SEEGER HOMES INC. - SALES OFFICE

SITE DEVELOPMENT PLANS  
LOT 3, APPALOOSA HIGHWAY 24 SUBDIVISION

**El Paso County – Request for Alternate for Seeger Homes Sales Office**

RE: Landscaping Plan Redlines and Alterations

SHEET NO:
C-01

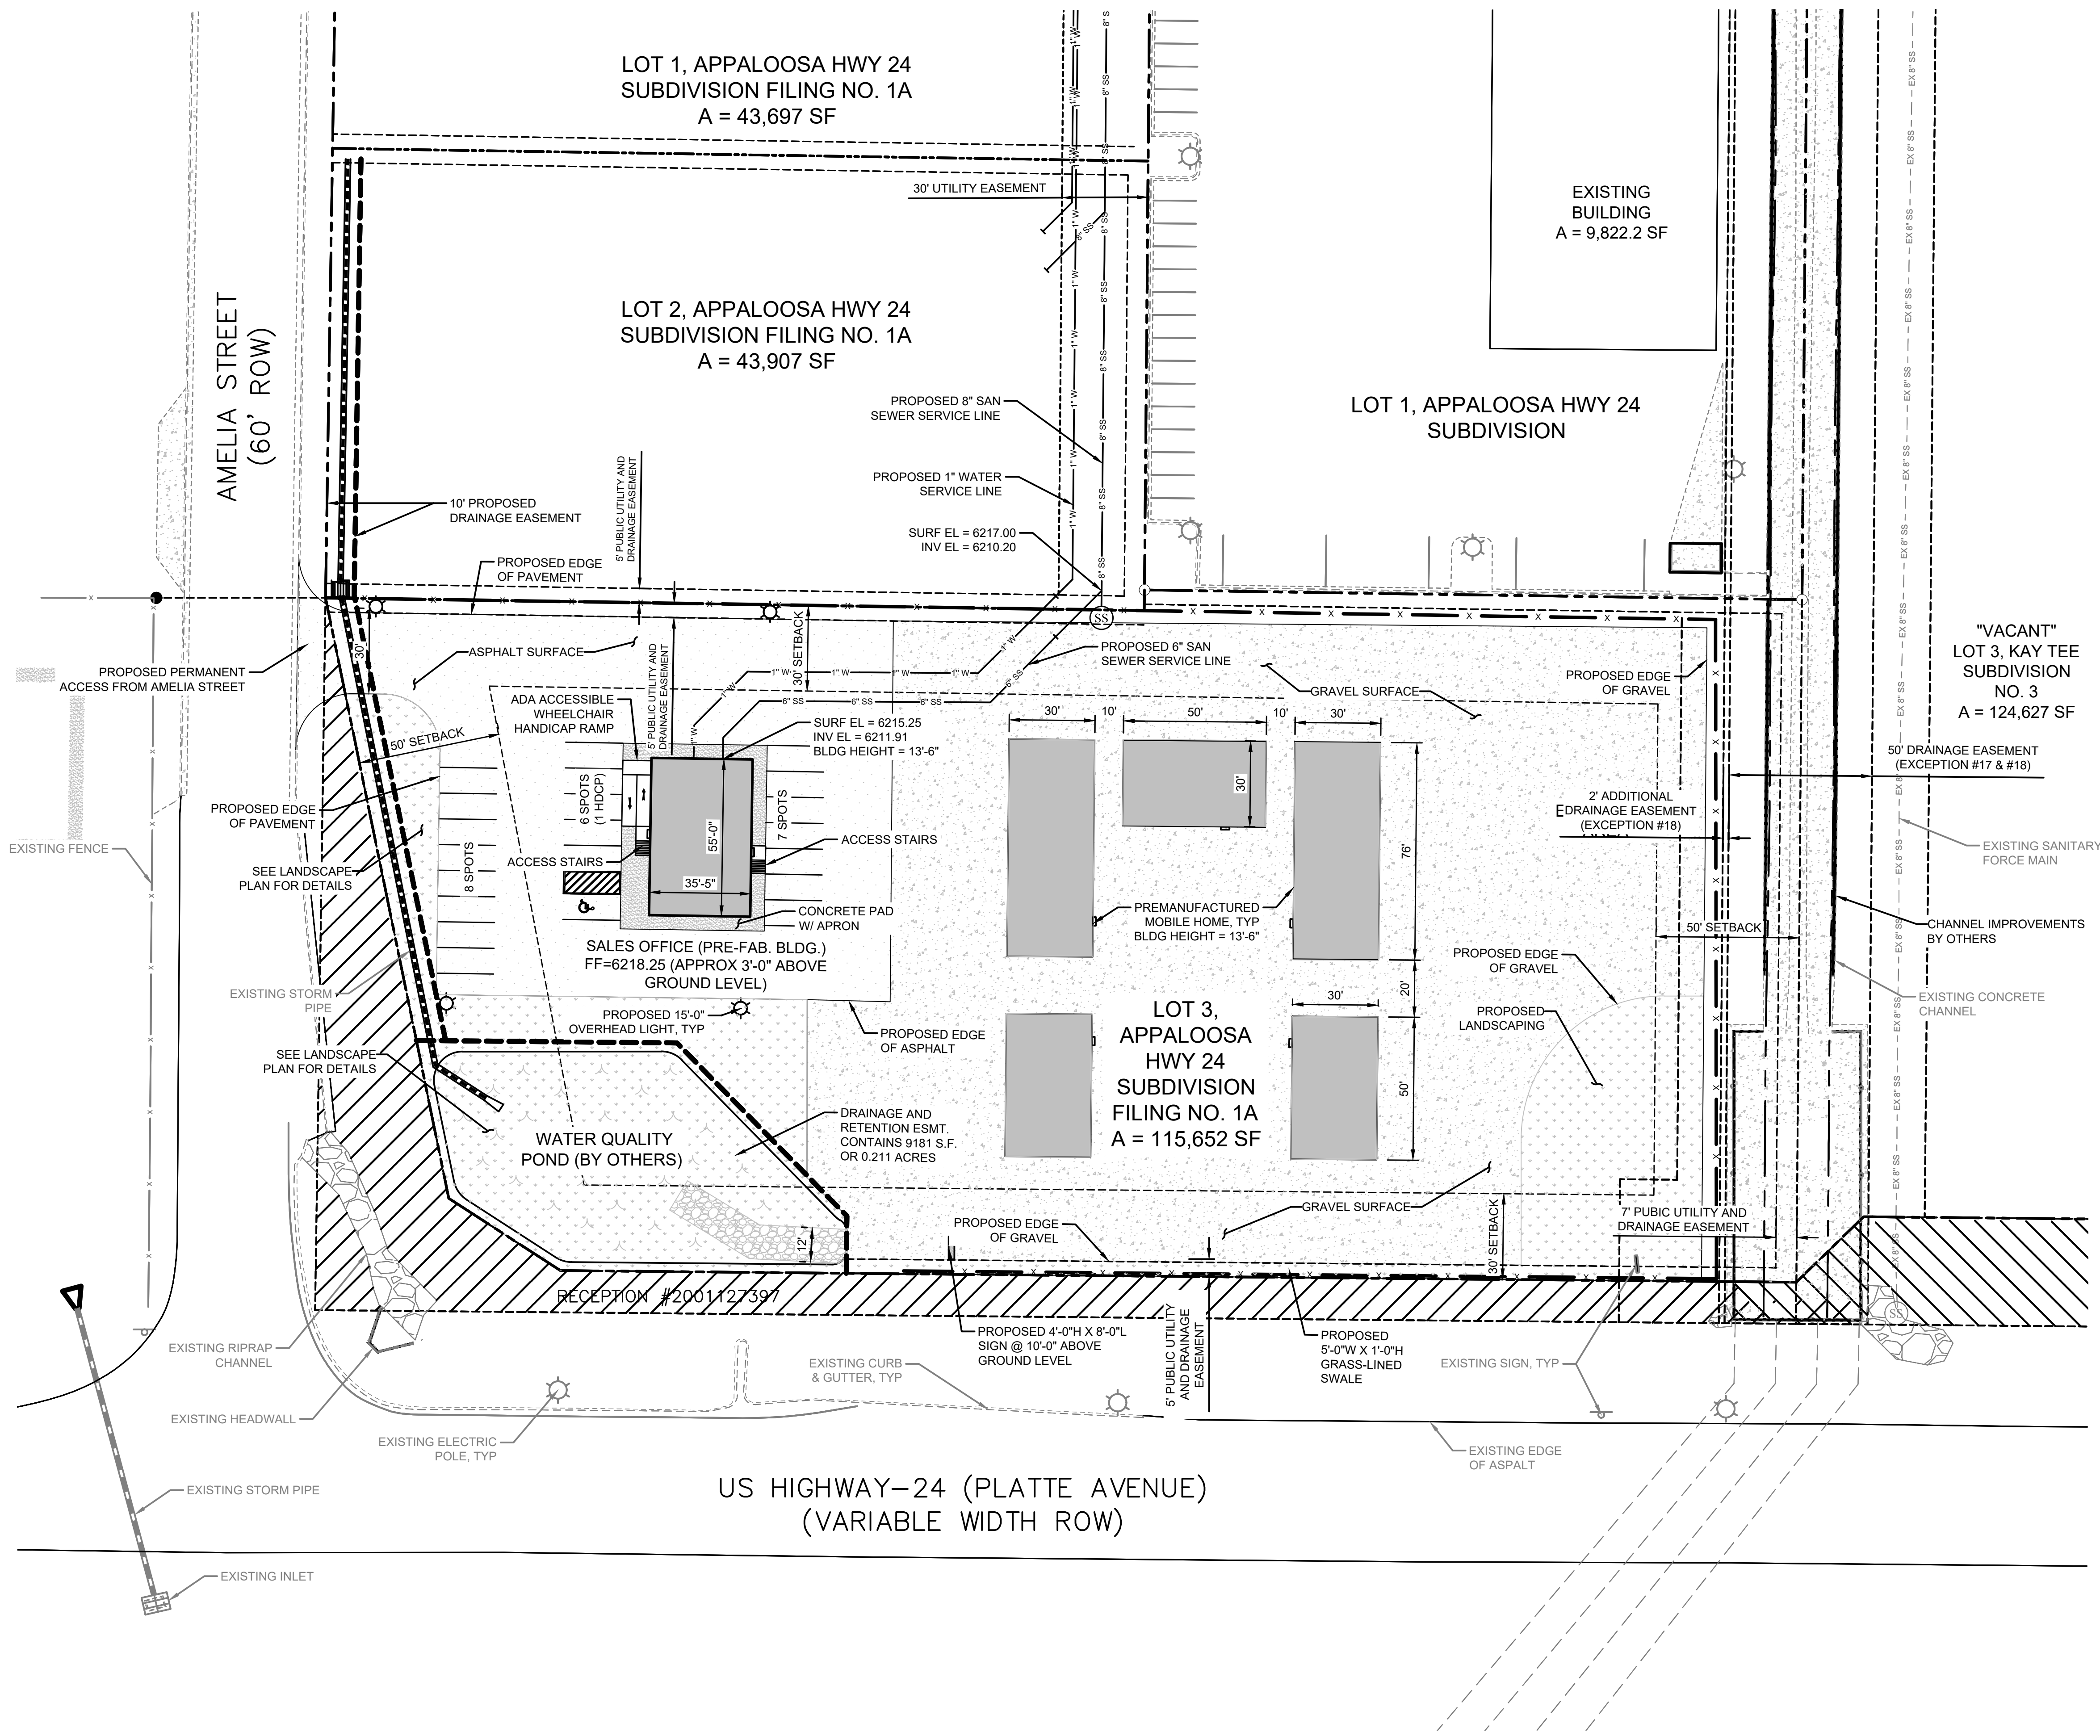
The grading and erosion control plan shows that a drainage swale is to be placed in this drainage easement. Per Plat Note #23 from approved Plat #14304, "Structure, fences, materials or landscaping that could impede the flow of runoff shall not be placed in drainage easements." Landscaping cannot be placed in the drainage swale located in the easement.

Additionally, a storm sewer pipe is located in the drainage easement. Placement of landscaping over top of the pipe could cause damage to the pipes in the future and require significant maintenance.

Placement of landscaping trees on top of the detention pond embankment may cause the embankment to breach in the future. Recommend not placing trees on the embankment or over top of the outlet pipe.
